TfNSW Reference: SYD21/00462  
Departments Reference: SSD-17647189

**REQUEST FOR SEARS – ACCESS LOGISTICS PARK - 884-928 - MAMRE ROAD, KEMPS CREEK**

Reference is made to the Department's correspondence dated 16 April 2021, requesting Transport for NSW (TfNSW) to provide details of key issues and assessment requirements regarding the abovementioned development for inclusion in the Secretary's Environmental Assessment Requirements (SEARs).

11213_DA011

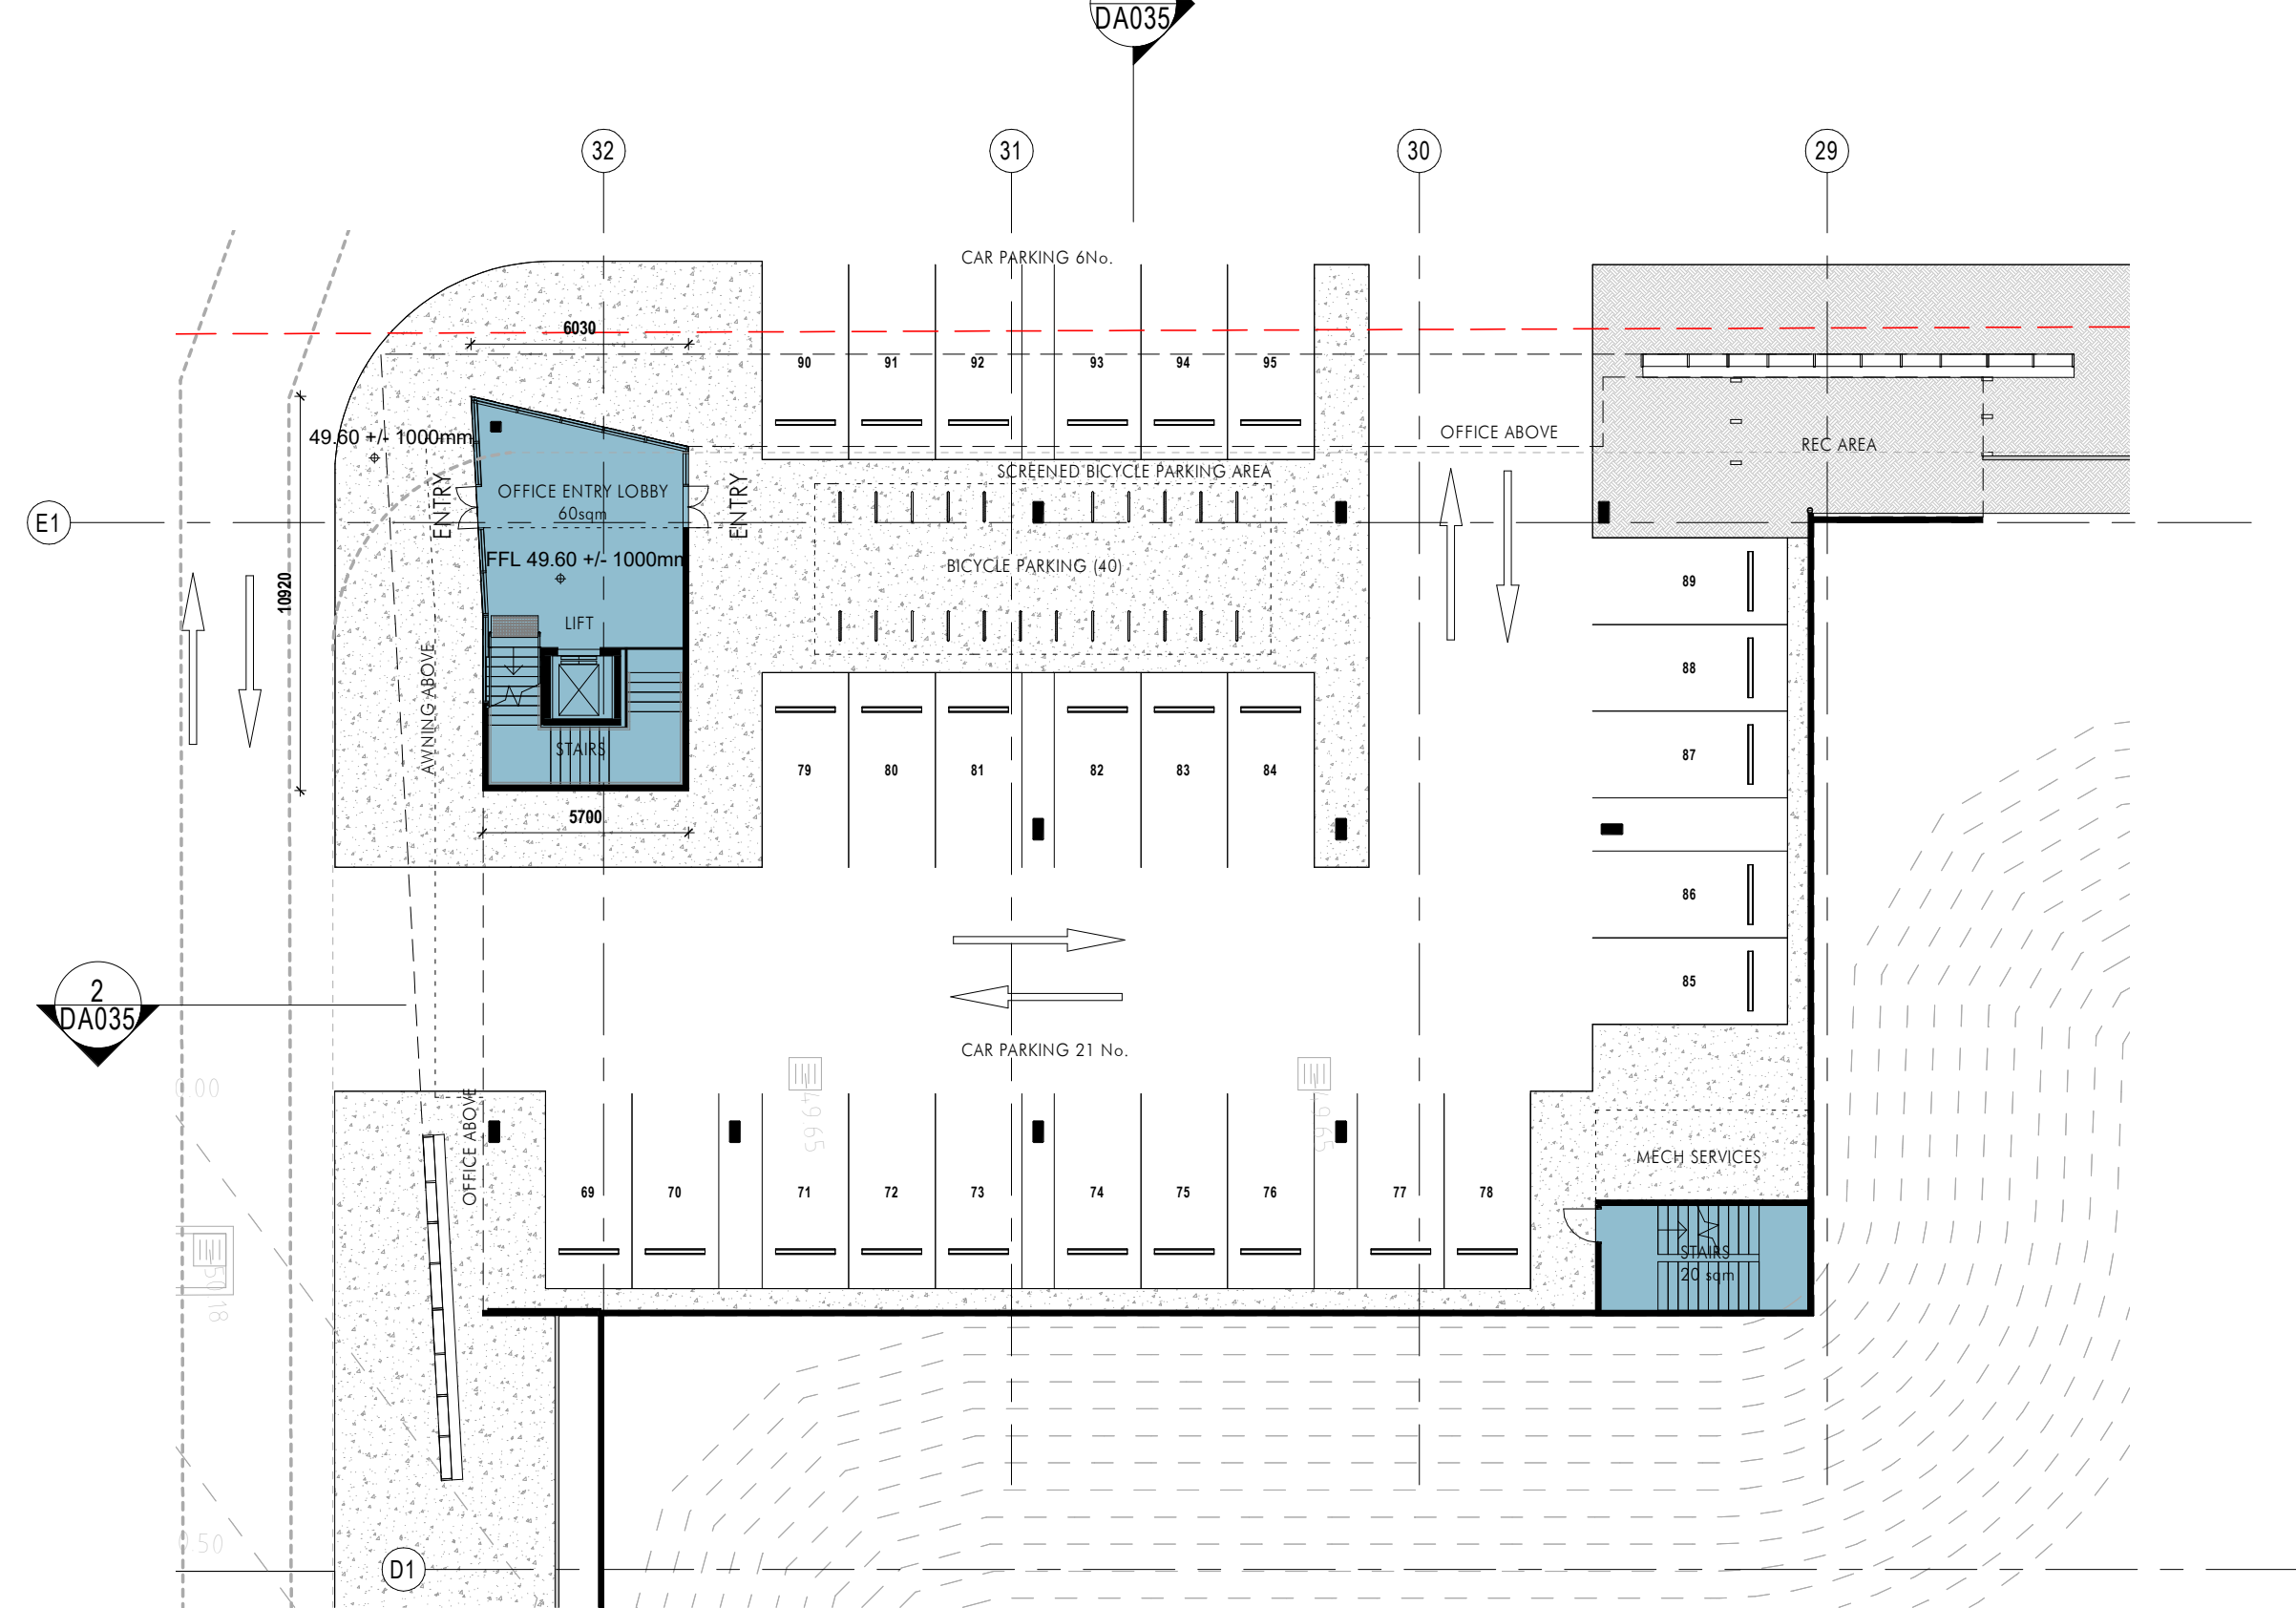
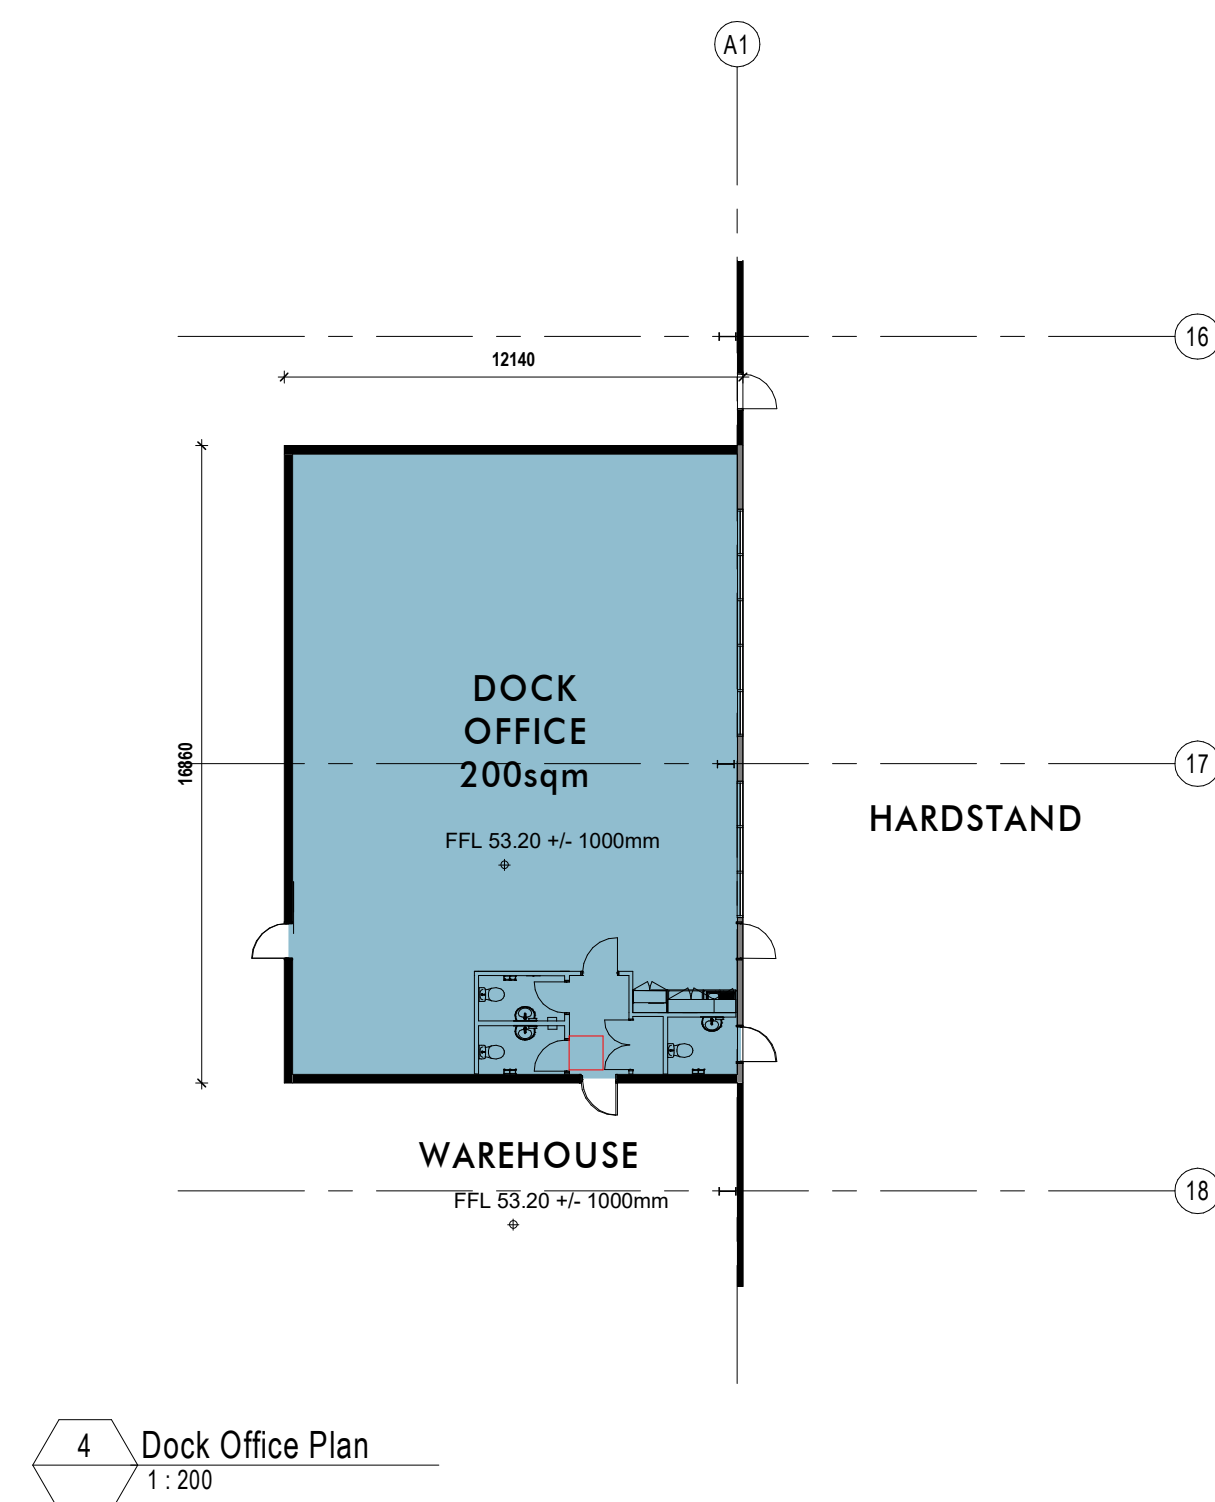
The preliminary site plan proposes a signalised intersection with Mamre Road at the southwest corner of the site. These signals are not inclusive on TfNSW Mamre Road upgrade strategic plan, however it is noted that they are proposed in the Mamre Road Precinct draft Development Control Plan (DCP). It is understood that the DCP has not yet been finalised and that currently there is an active investigation by AsonGroup on behalf of the Land Owners Group into whether signals at this location are warranted to alleviate traffic from other intersections along Mamre Road.

In this regard, subject to the finding of the traffic modelling investigations, TfNSW recommends that alternative options are investigated and modelled for review. This should include but not be limited to a temporary access from Mamre Road until the ultimate local road network is delivered and the connection to ultimate local road network with no access to Mamre Road.
